MEMORANDUM

SUBJECT: Thrall Road Short Plat SP-11-00009

THRALL ROAD SHORT PLAT
PART OF SECTION 27, T. 17 N., R. 19 E., W.M.
KITITAS COUNTY, WASHINGTON

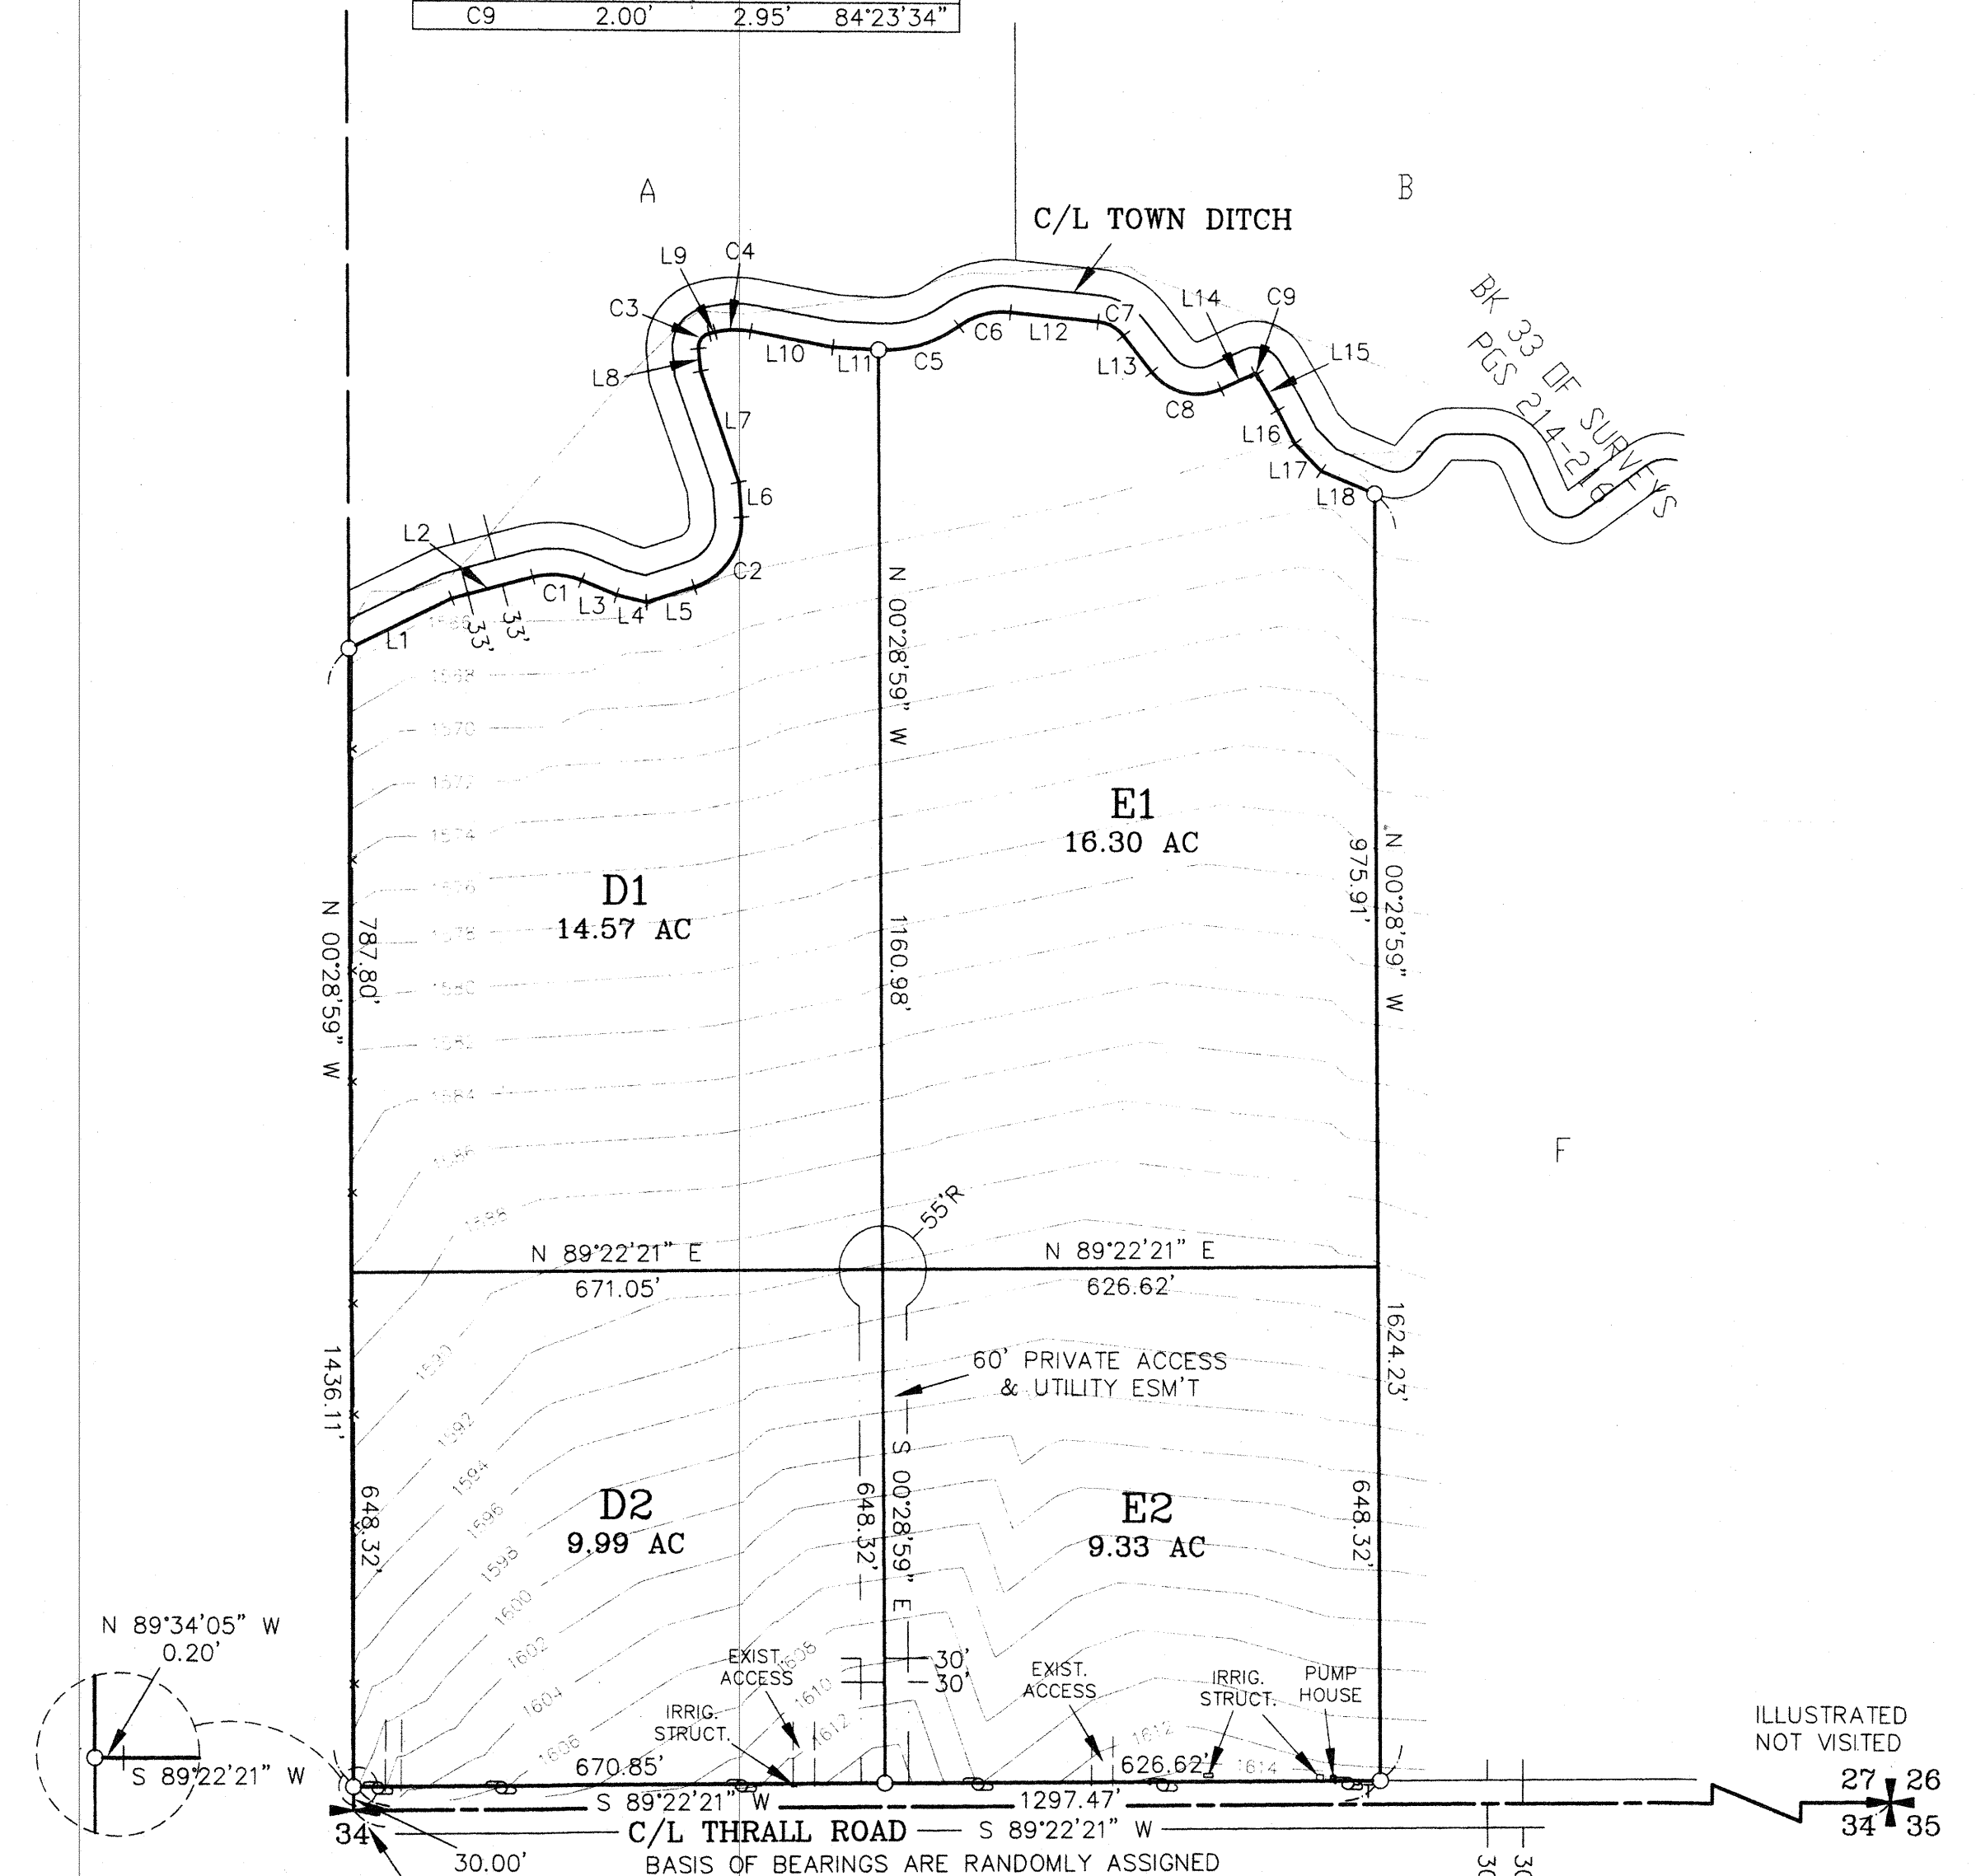
3. Existing Approaches: At the time of application for the new approach to construct the private road, the three existing approaches may be required to be removed.

4. Private Road Improvements: Access shall be constructed as a Low-Density Private Road. See Kittitas County Road Standards, 9/6/05 edition.
 - a. Access easements shall be a minimum of 60' wide. The roadway shall have a minimum width of 20', with 1' shoulders, for a total width of 22'.

5. Cul-de-Sac: A cul-de-sac turn-around having an outside right-of-way or easement diameter of at least 110 feet shall be constructed at the closed end of all dead-end roads serving 3 or more lots. The driving surface shall be at least 96 feet in diameter. Cul-de-sacs must also conform to the requirements specified by the 2006 International Fire Code. Contact the Fire Marshal regarding any additional cul-de-sac requirements.
